RE: **Commercial Addition, Lot 5-A, 11-A, 13-A, & 15-A, Block 2**
Grading and Drainage Plan
Engineer's Stamp Date 3/28/2018 (J14D186)

Based upon the information provided in your submittal received 3/30/2018, the above referenced plan is approved for Preliminary Plat and Work Order.

Lots 5-A, 11-A, 13-A and 15-A, Block 2 Commercial Addition GRADING PLAN			
DRAWING: 201622-GD.DWG	DRAWN BY: SH-B	DATE: 3/25/2017	SHEET # 1

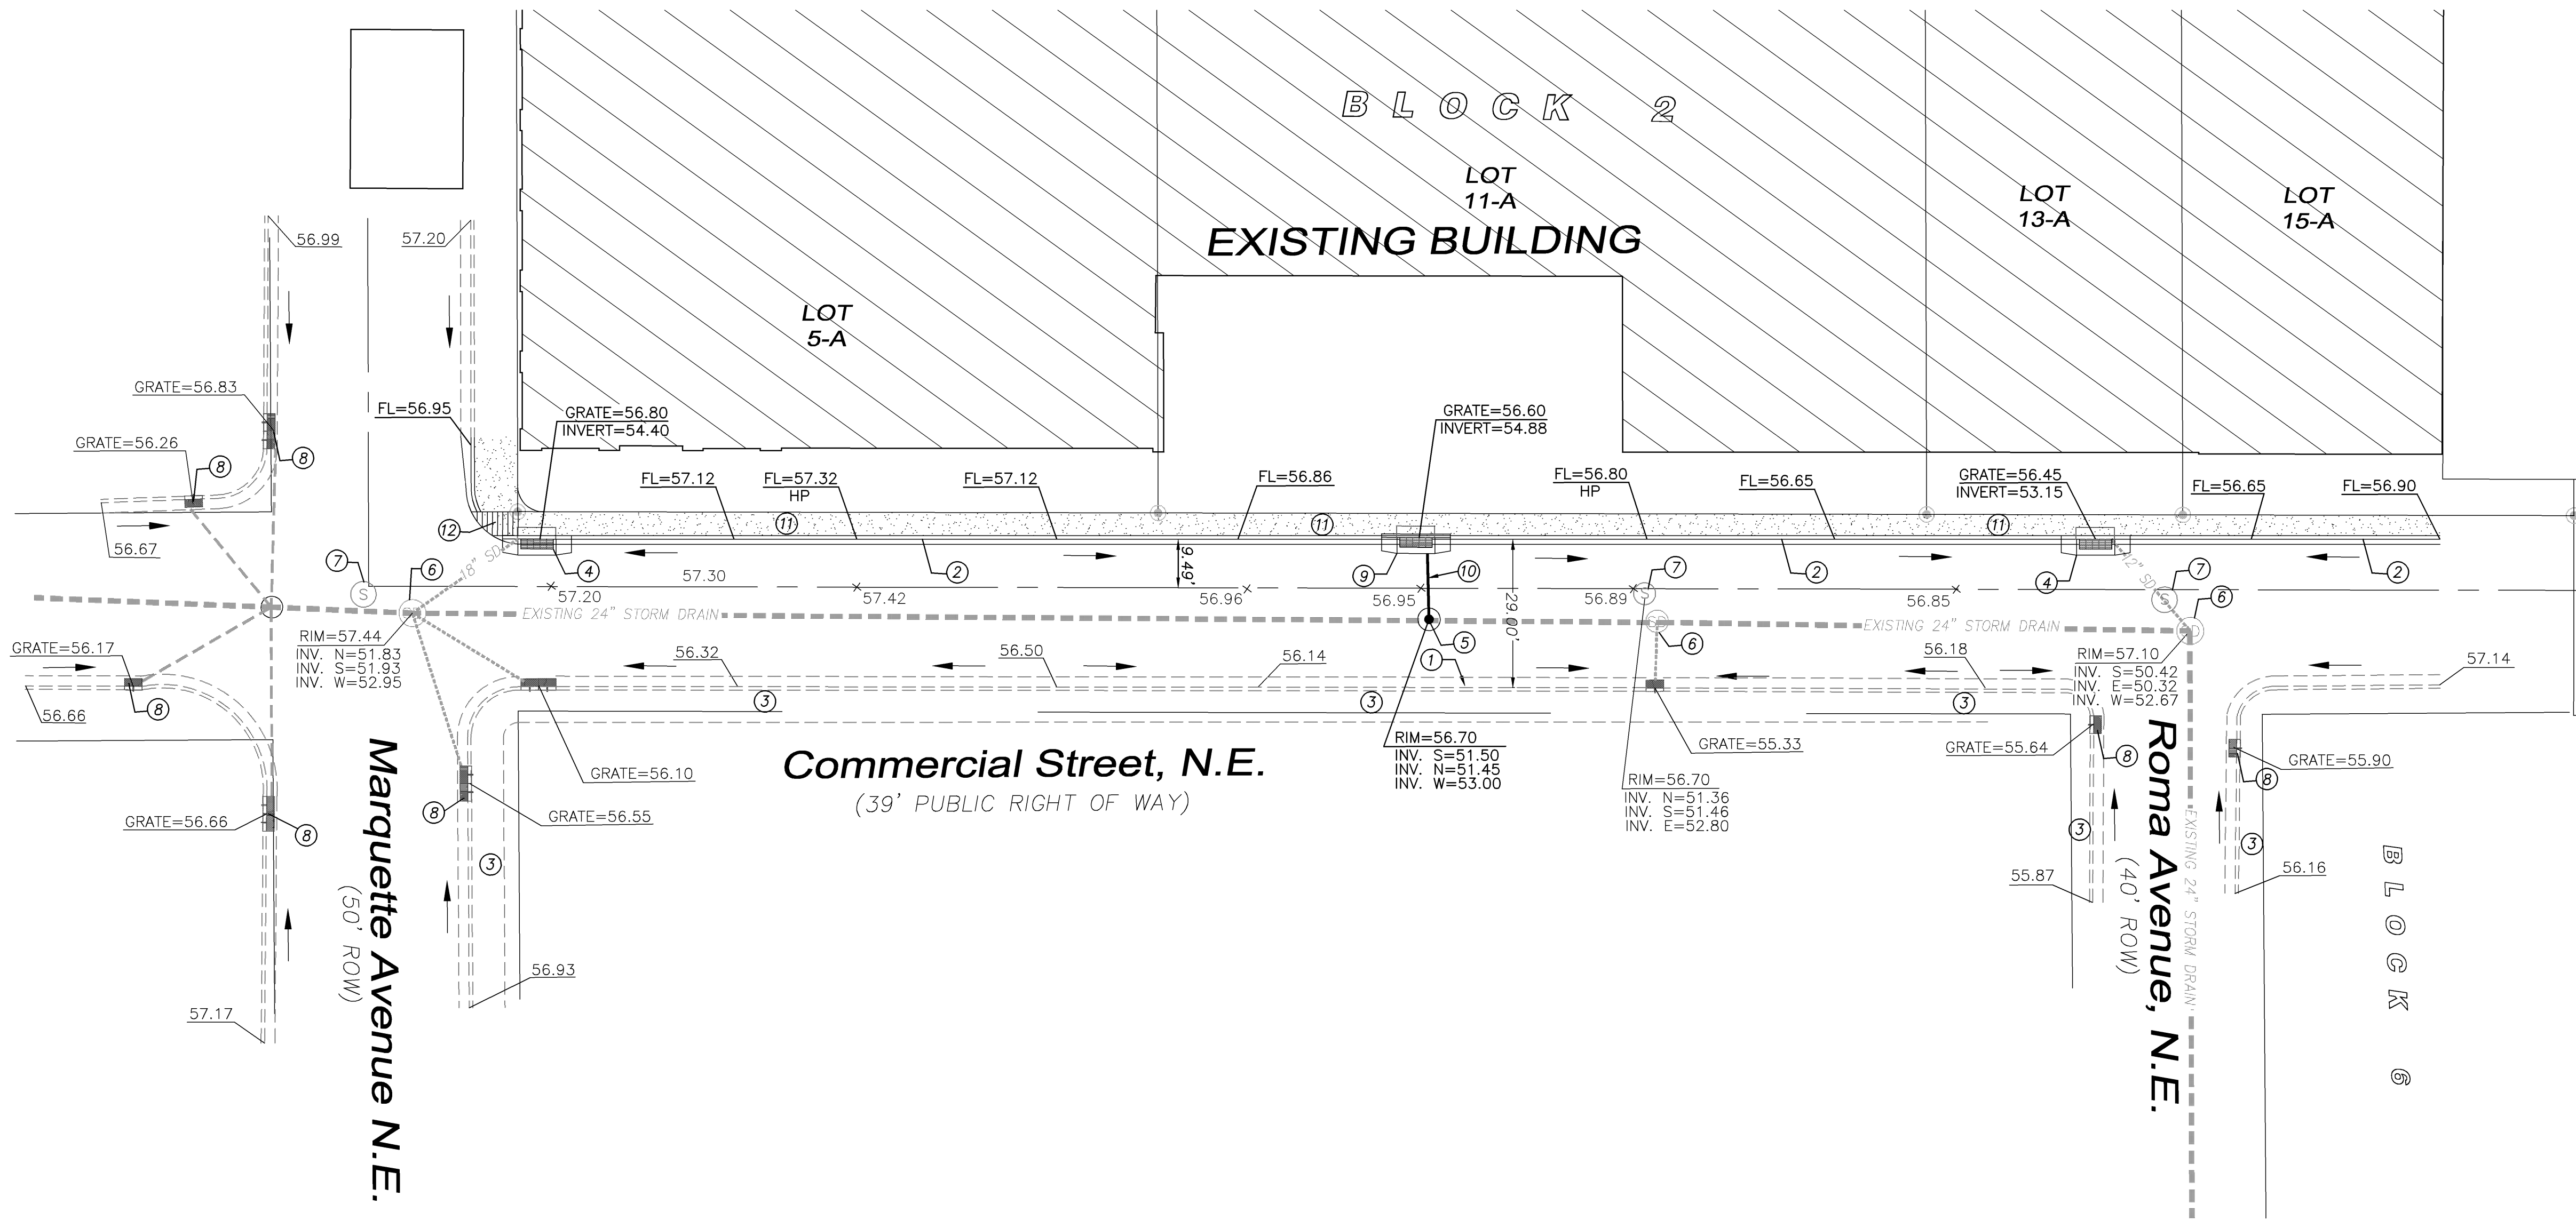
Please include the plan in the Work Order plan set and label the sheet "For Information Only". The construction plans must include more specific construction notes including, removal notes, inlet types, typical sections, and pipe lengths and slopes.
